Date: 4 March 2015

**Application by National Grid Carbon Limited for an Order Granting Development Consent for the Yorkshire and Humber CCS Cross Country Pipeline
Document 12.5: Protocol for Delivering Biodiversity Enhancement
Submission by North Yorkshire County Council for Deadline 4**

I am sending North Yorkshire County Council's (NYCC) response to the submission by National Grid (NG) at Deadline 3 of Document 12.5: Protocol for Delivering Biodiversity Enhancement.

TITLE SKERNE BLOCK VALVE  
PLANTING DRAWING  
APFP REGULATION 5(2)(0)  
PINS REFERENCE No: EN070001  
DOCUMENT REFERENCE 2.51

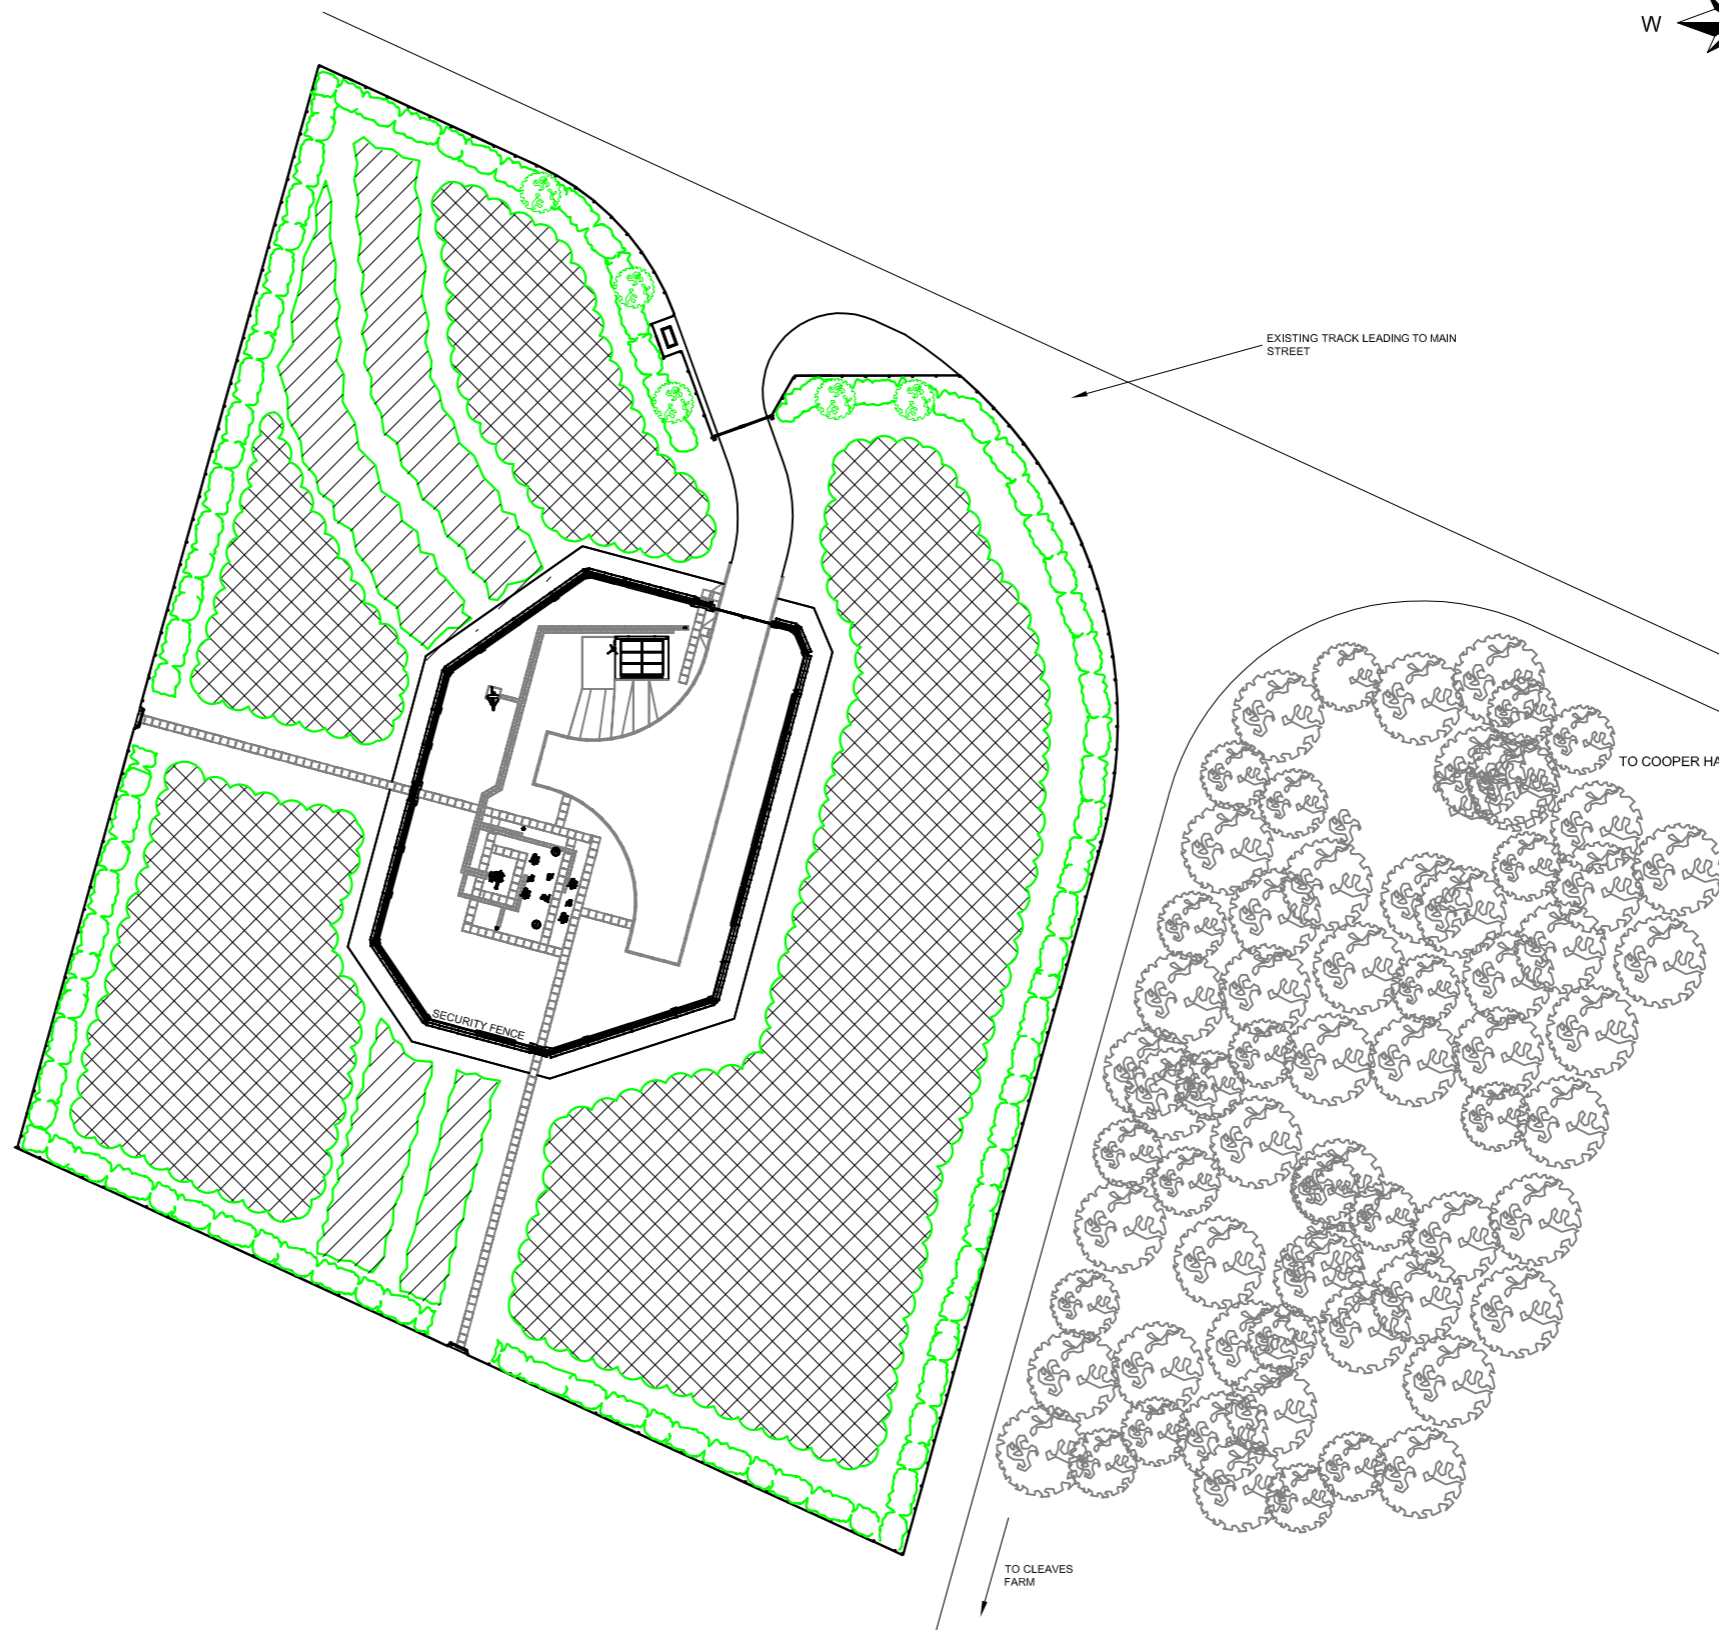
The enhancements set out for the AGIs are acceptable and have previously been agreed. With regards to the 'six additional enhancement measures' it is noted in 5.3.28 of the Planning Statement (document 7.1) that bat boxes will be included at each of the AGIs where appropriate. Currently the table only has bat boxes at one of the six AGIs. NG should commit to investigating the opportunities at the other five AGIs.
